Engineers Comments Regarding Surface Water Drainage

Application Reference:	M/20/26/PL	Reviewer Reference:	ADC/KW/PC
Planning Officer:	Harry Chalk	Date of Review:	03/06/2026
Site Name:	86 Ancton Way Elmer PO22 6JP		
Application Description:	Demolition of existing bungalow and construction of replacement dwelling (resubmission following M/58/25/PL).		
Assessment Number:	2 of 2

PROPOSED SURFACE
WATER DRAINAGE
Scale 1:100

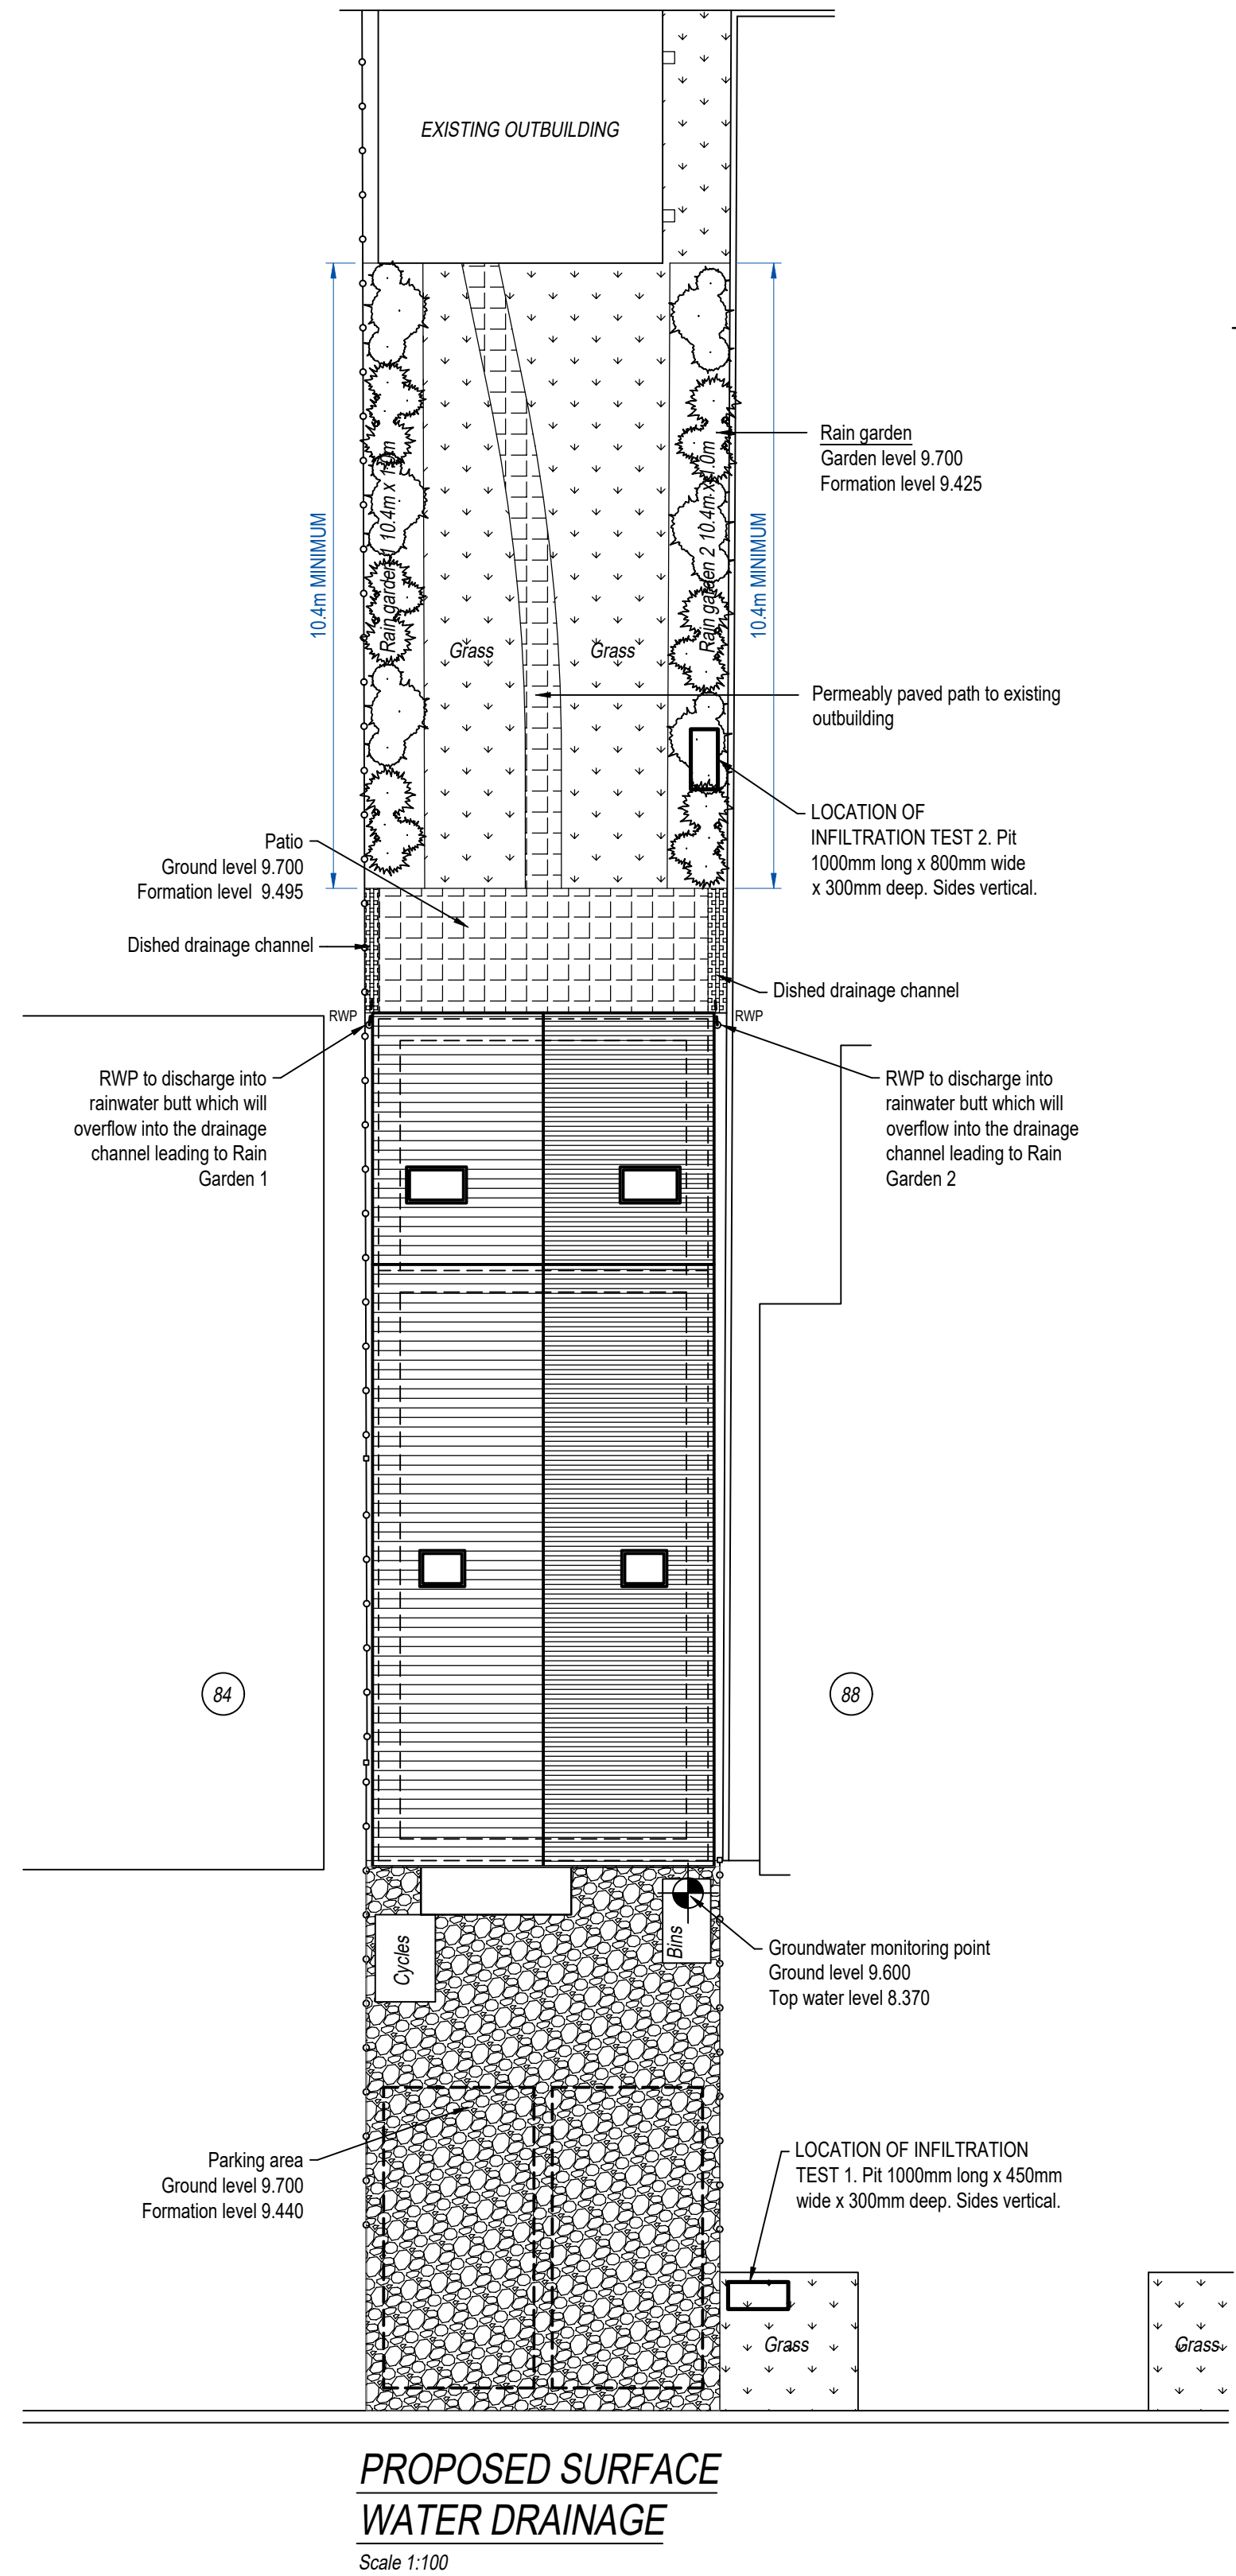
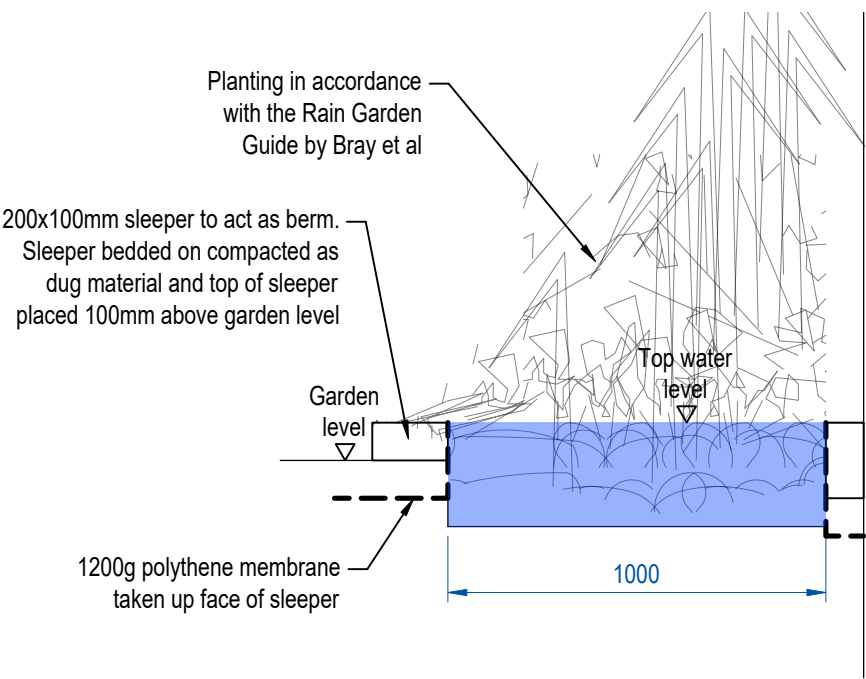
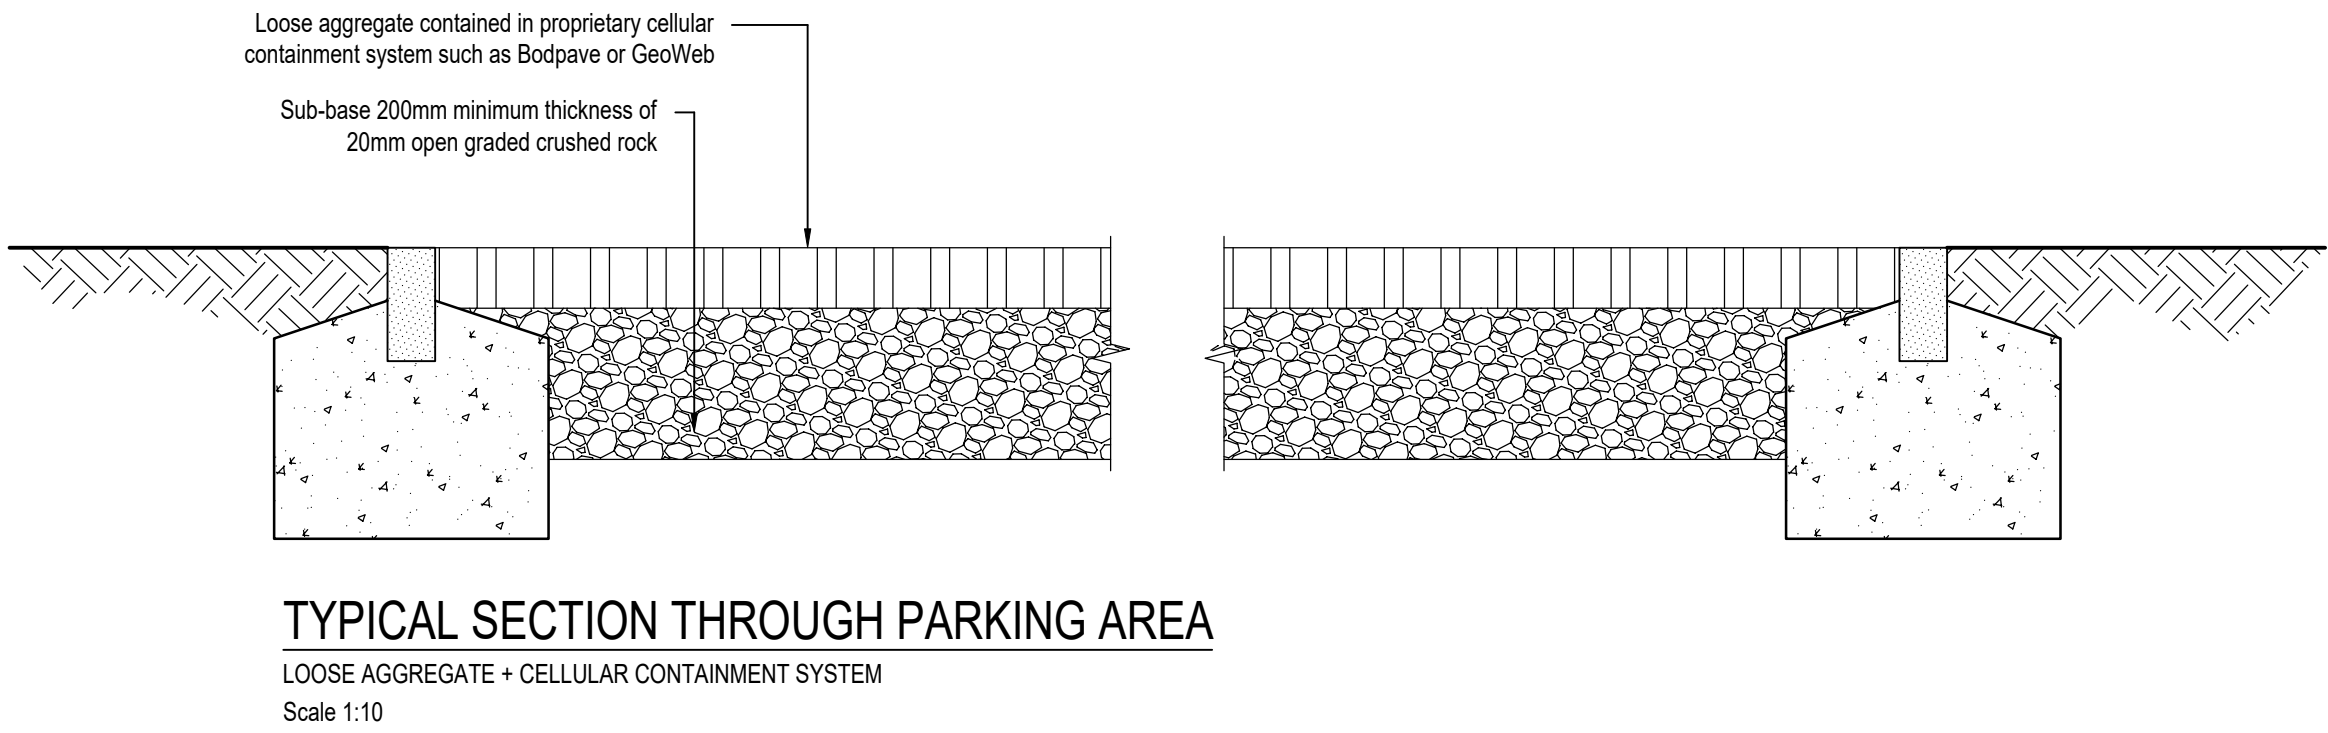
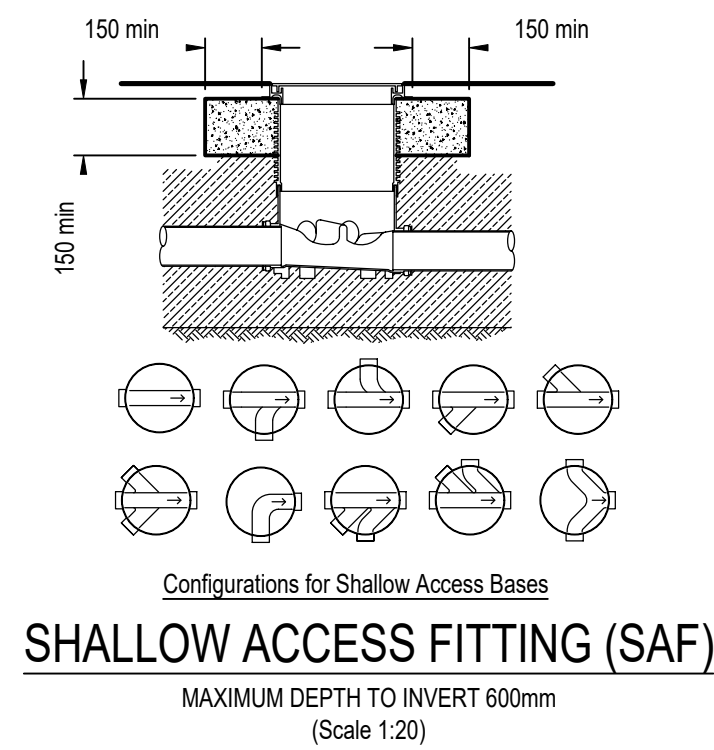
1.1. The designer proposes to drain the roof area of the new dwelling into two rain gardens running alongside both side boundaries via rainwater butts. All other hard surfaces, including the driveway, are to be of permeable construction. We are supportive of the use of infiltration as the second-highest priority disposal option (after water reuse). Two shallow infiltration test pits have been tested in accordance with industry guidance; these are shown on plan and positioned in the front and rear gardens. The slowest infiltration rate calculated was $2.9 \times 10^{-5} \text{ m/s}$. This is the rate that has been used to inform the SuDS design.

1.2. The design positions the permeable paving to the rear and the rain gardens at no lower than 9.425 m AOD, and the drive to the front at no lower than 9.440 m AOD. This is above the minimum allowable level of **9.370 m AOD**, as evidenced during the compliant groundwater monitoring undertaken in 2024/25. This is acceptable.

1.3. A site-specific porosity value of 75% has been agreed with the applicant and applied to the proposal. This now allows for plant species to mature within the garden without increasing the risk of flooding of the gardens.

Water butts, permeable paving and rain gardens are proposed. As infiltration has been proven viable these are considered acceptable to accept extreme rainfall conditions.
